CITY OF ALBUQUERQUE

**RE: Entertainment Facility
3930 Pan-American NE
Grading and Drainage Plan
Engineers Stamp Date: 2/16/18
Hydrology File: G16D145A**

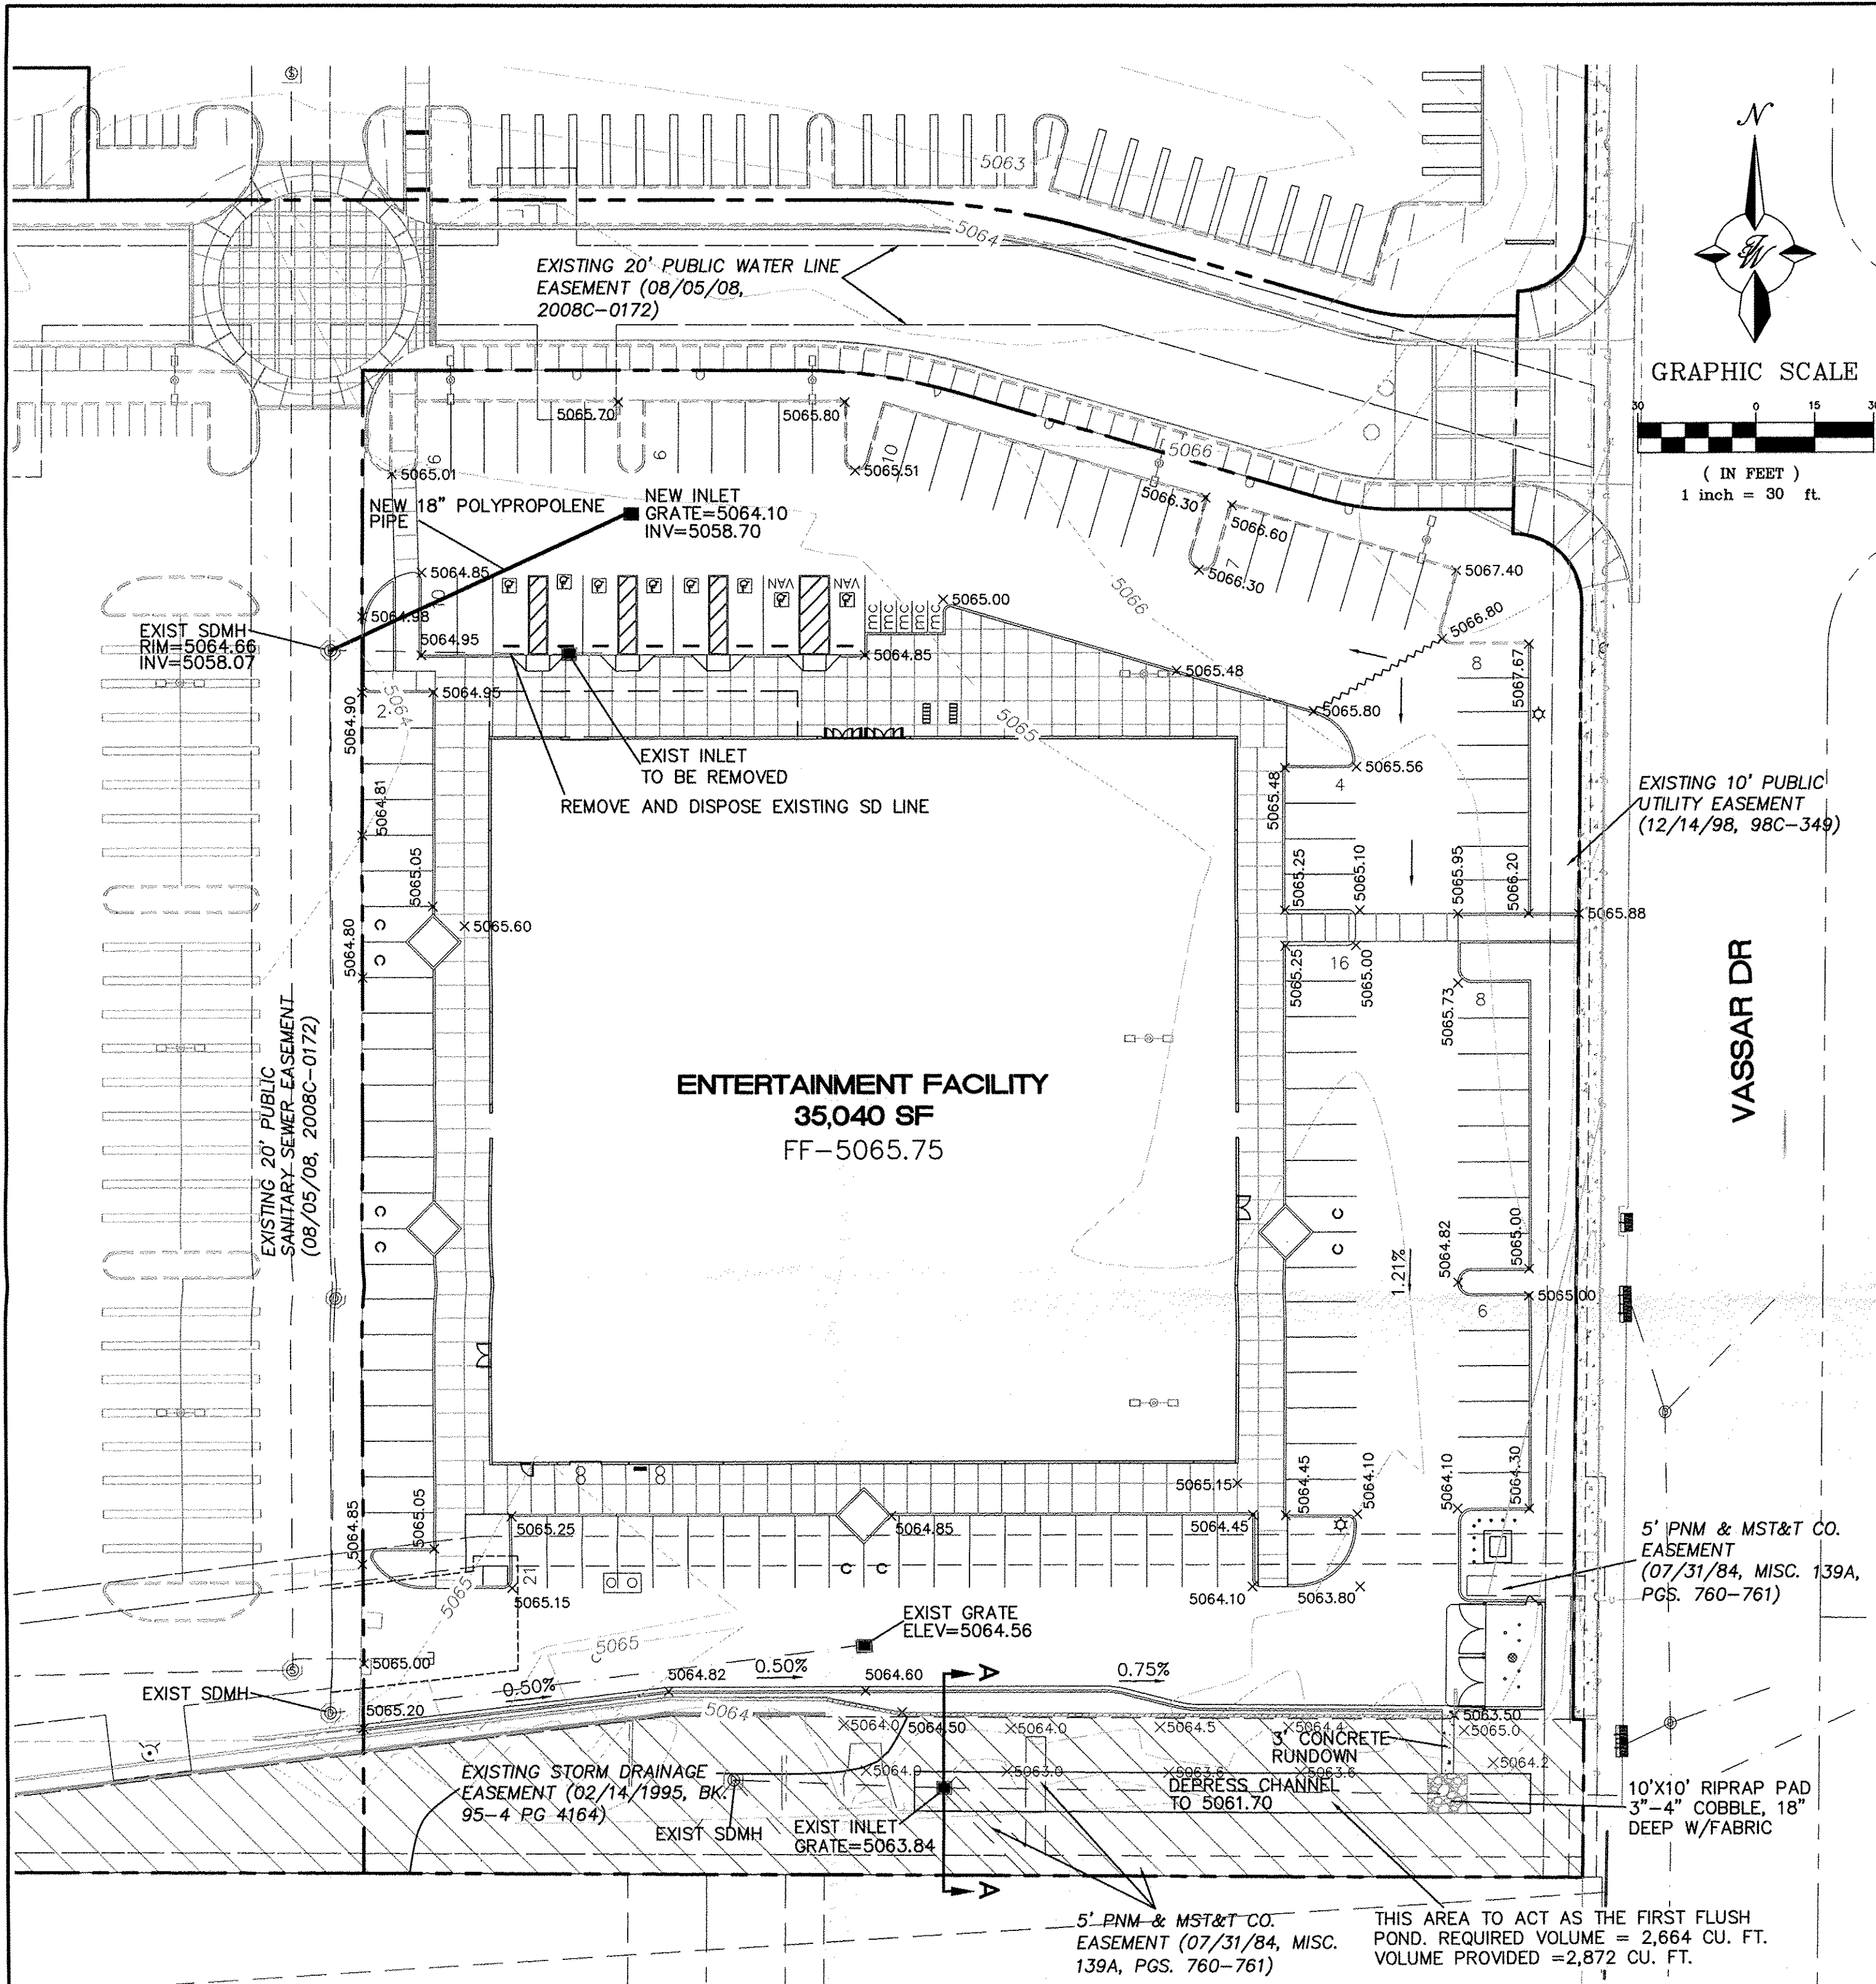
1. The first flush pond(s) need to be sized for the areas draining to them. Calculate the first flush requirement for each subbasin within the project site, including the western edge of this project site that is not delineated. Show how the first flush runoff will be retained on-site from each subbasin.

2. If unable to retain on-site, the runoff that bypasses the first flush ponds will need to be quantified and stated on plans.
3. Payment of Fee-in-Lieu will be required for the bypass volume at a rate of \$8/CF. this appears to be all of Basin 1 and the non-delineated western edge.

4. The southern drainage easement is currently being used for surface drainage. The construction plans for the drainage easement (SAD216 CPN: 3960) show an earthen drainage channel with cement treated base (CTB) dikes, a flow depth of 0.33', and a 48" storm drain beneath. The current proposal to use it as a first flush facility is unacceptable until it can be demonstrated that the new pond will not interfere with the function of this channel.

6. Additional detail will be needed for the pond(s), including top of pond elevations, actual and required volume and water surface elevations with respect to walls and property lines.
